DEPARTMENT OF PARKS AND COMMUNITY SERVICES

October 20, 2023

Subject: Retreat at TimberRidge Filing No. 3 Final Plat, Review #2 (SF-22-041)

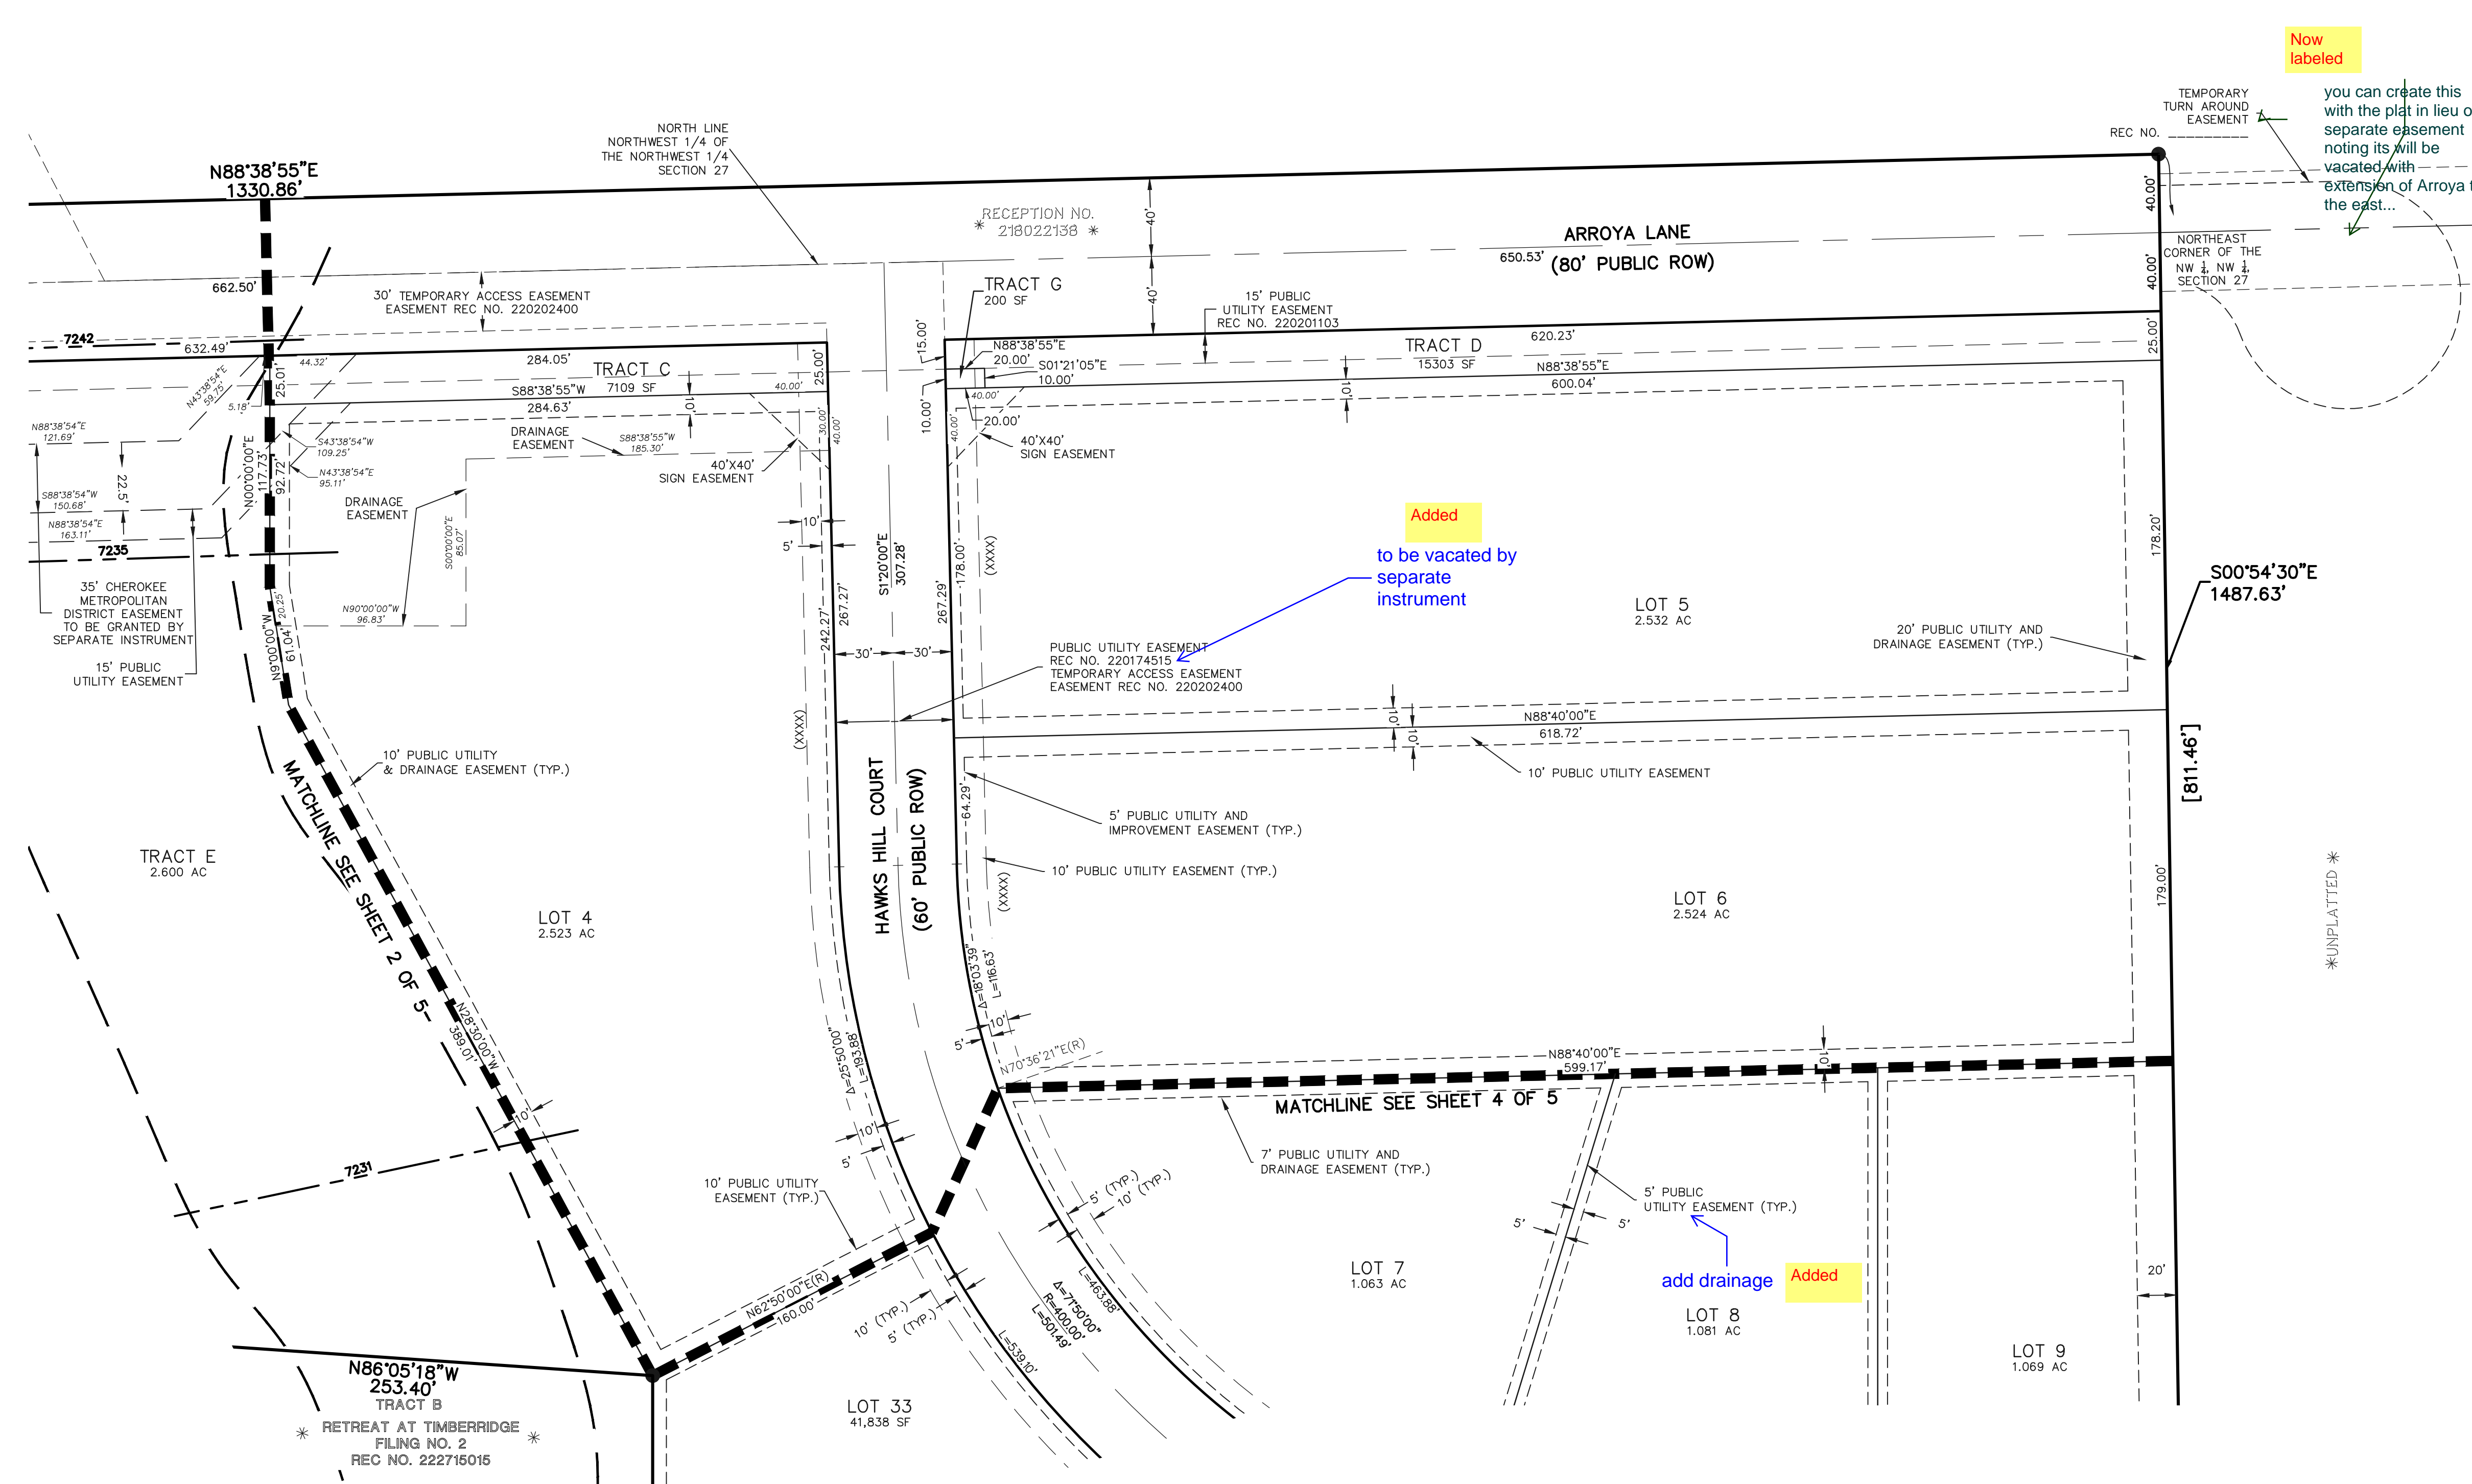
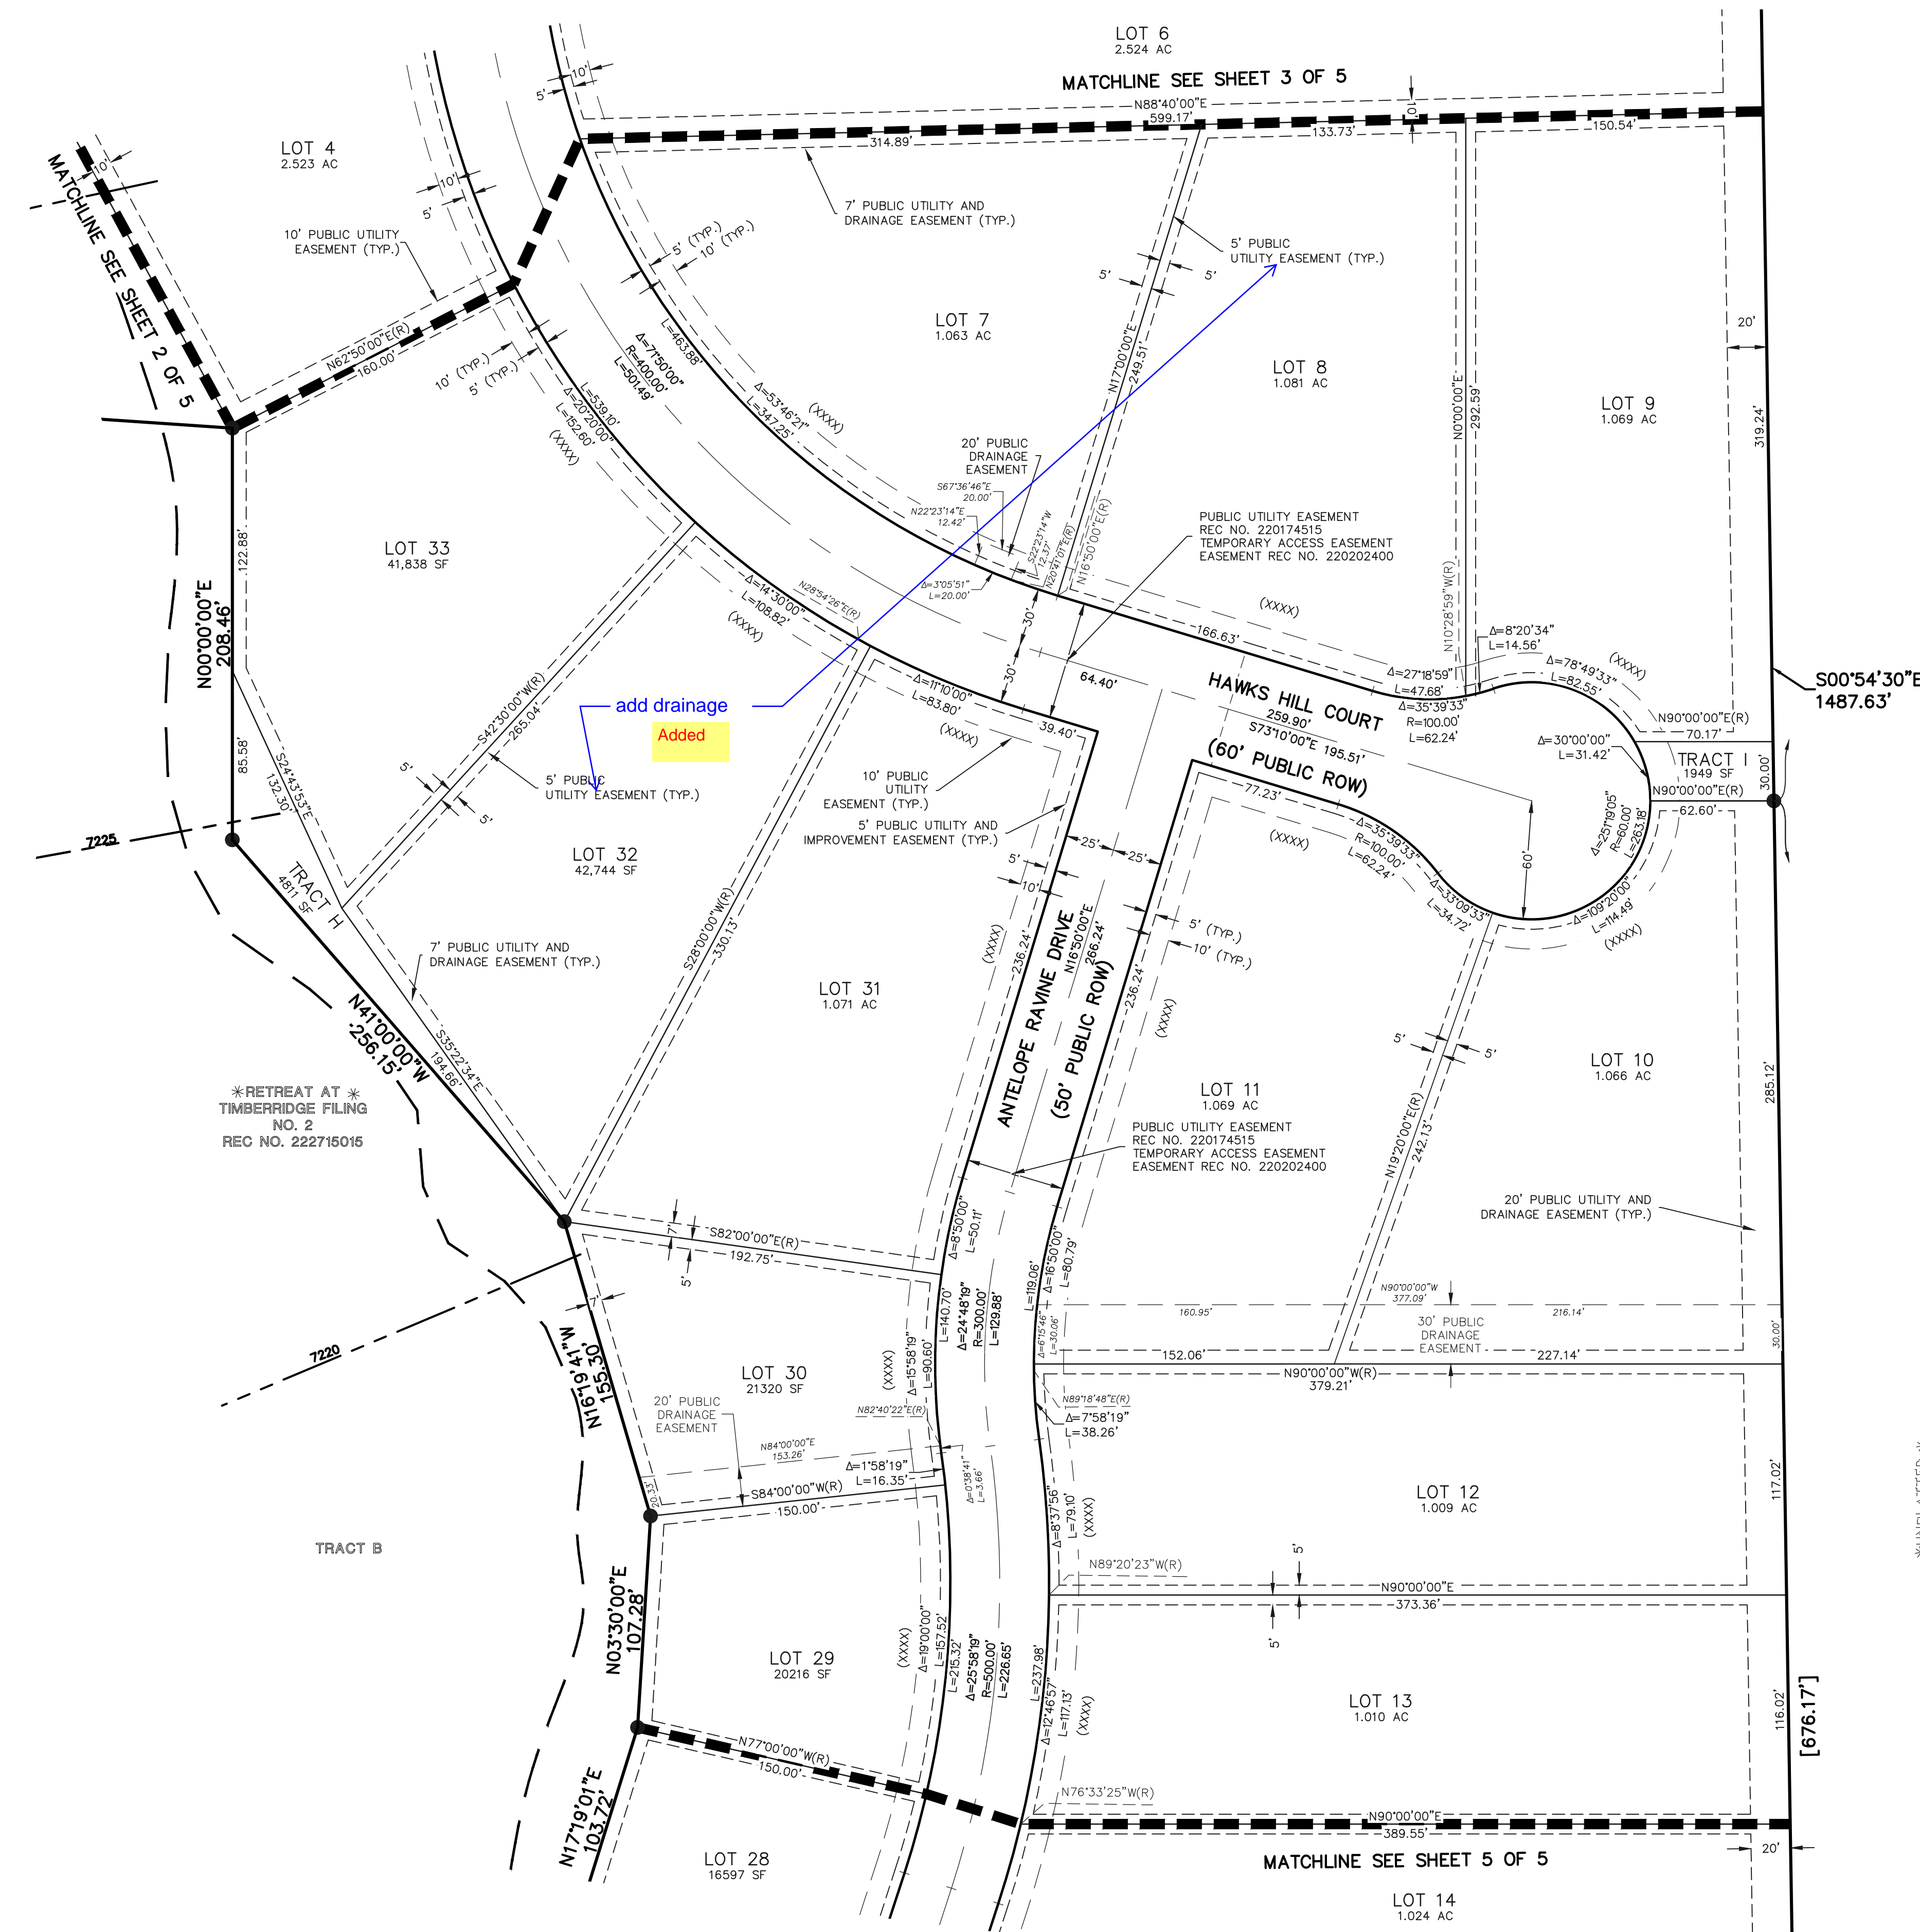
As noted in the comments and recommendations below and because Tracts A-D are to be owned by The Retreat Metropolitan District No. 1, the applicant must show and label the required 25' regional trail easements within the aforementioned Tracts. Staff understands that Tract H will be owned by El Paso County and therefore does not require the dedication of the regional trail easement, however, for continuity, the applicant may show a trail easement within Tract H.

The Retreat at TimberRidge Filing No. 3 Final Plat shows a 30' trail easement dedicated to the Sand Creek Regional Trail, running north-south on the west side of Sand Creek. According to the plat, this trail easement terminates at Arroyo Lane, and no additional trail easements are designated along Arroyo Lane, either east or west of Sand Creek. While the 2018 Retreat at TimberRidge Preliminary Plan did highlight the trail corridor along Arroyo Lane, only the Filing No. 3 Construction Drawings show what appears to be a trail along the south side Arroyo Lane. **If the Arroyo Lane Regional Trail easement is indeed located within Tracts A-D and outside of the designated Arroyo Lane right-of-way, the plan must be symbolized and annotated to show them in a clear and discernable manner.**
